**From:** Sue Howell <Sue.Howell@arun.gov.uk>  
**Sent:** 03 June 2025 16:57  
**To:** Planning.Responses <Planning.Responses@arun.gov.uk>  
**Cc:** Simon Davis <Simon.Davis@arun.gov.uk>  
**Subject:** Planning Consultation on: LU/76/25/PL

**Application ref:** LU/76/25/PL

Demolition of vacant supermarket building and erection of four-storey hotel with ancillary restaurant, public realm, associated works. This application affects the setting of listed buildings and affects the character and appearance (Rated) as other development.

**Location:** Former Waitrose Site Avon Road Littlehampton BN17 6AT

Landscape Masterplan

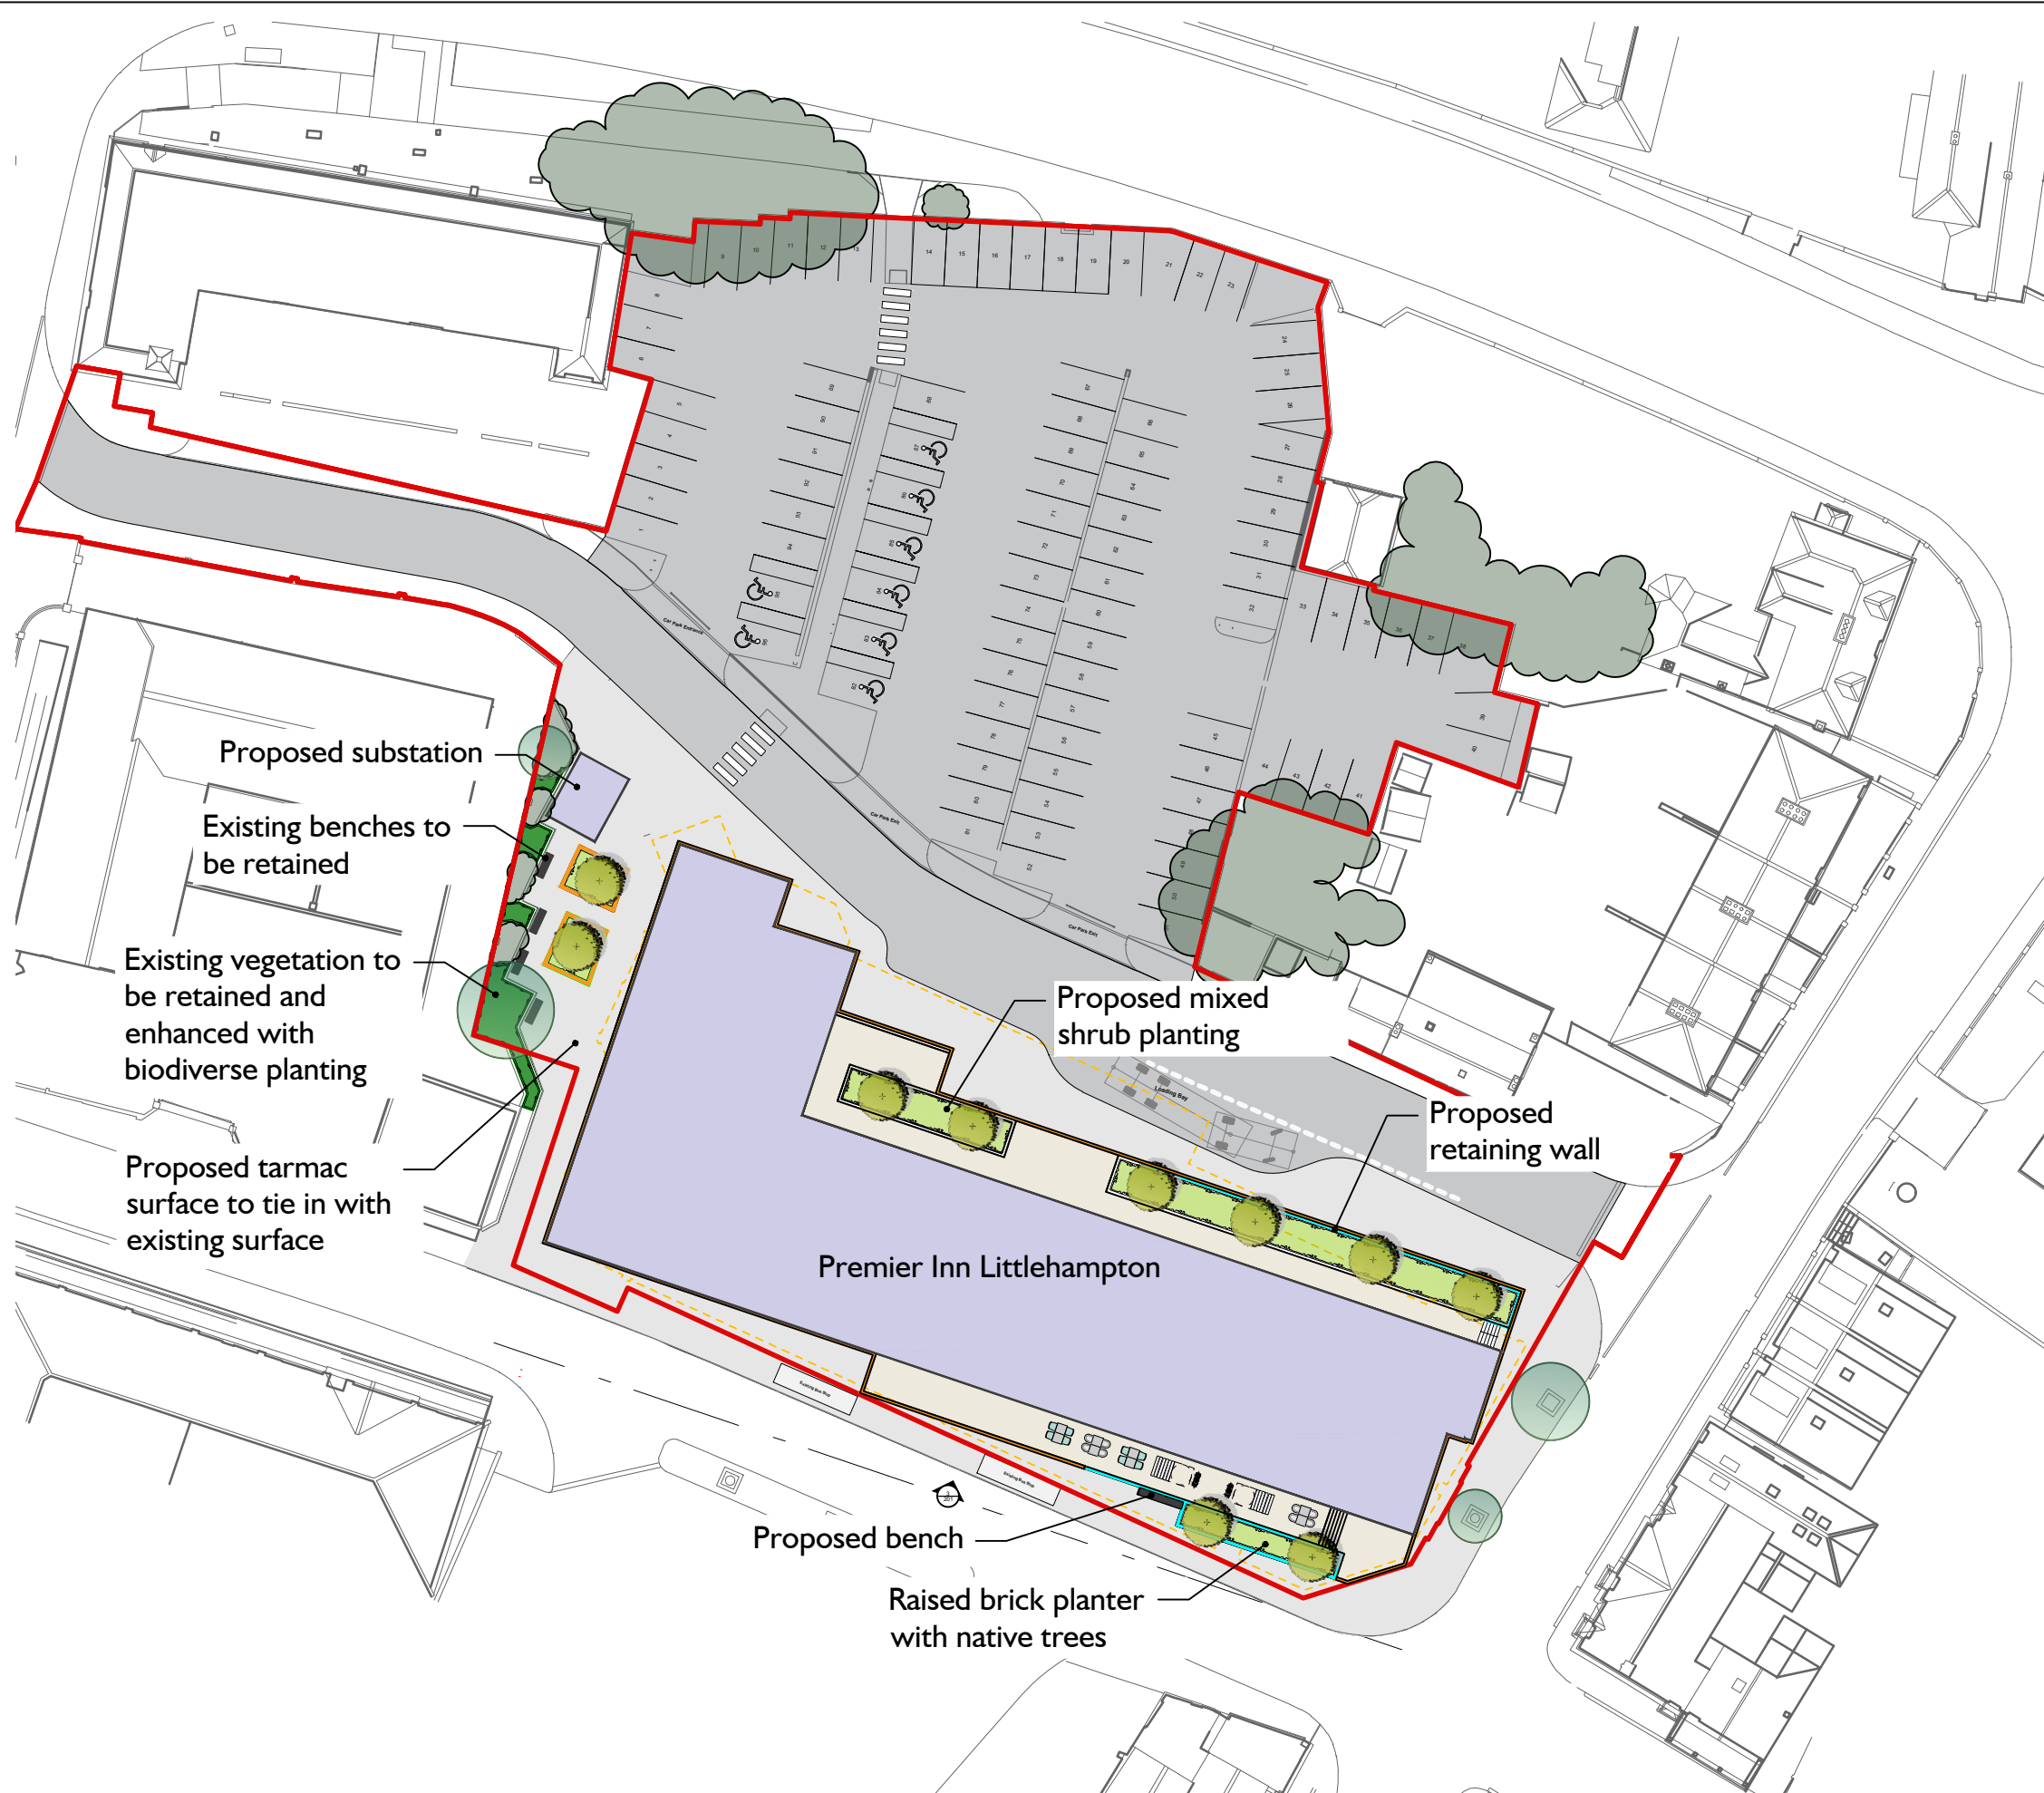
The landscape proposals are minimal, but would appear appropriate for the application and setting. The proposals include the formation of large raised planters to address the changes in level around the corners of the new building, maintaining the slope of the pavement whilst creating a level terrace for external seating. Soft Landscaping proposals include raised and level planters around the building with native and semi-ornamental shrub planting proposed. To the North/East of the building is proposed a raised wall which will form a rain garden. Planting to consist of native, biodiverse, shade tolerant shrubs, ground covers and climbers. Semi-ornamental planting around the building with native trees and specimen shrubs.

It is noted that all existing vegetation on the site is to be retained.

Details of the landscape proposals will be required to be submitted and confirmation of increase in biodiversity net gain and habitat. Landscape proposals would need to be submitted in plan form detailing species choice, quantities, planting densities and size at time of planting.
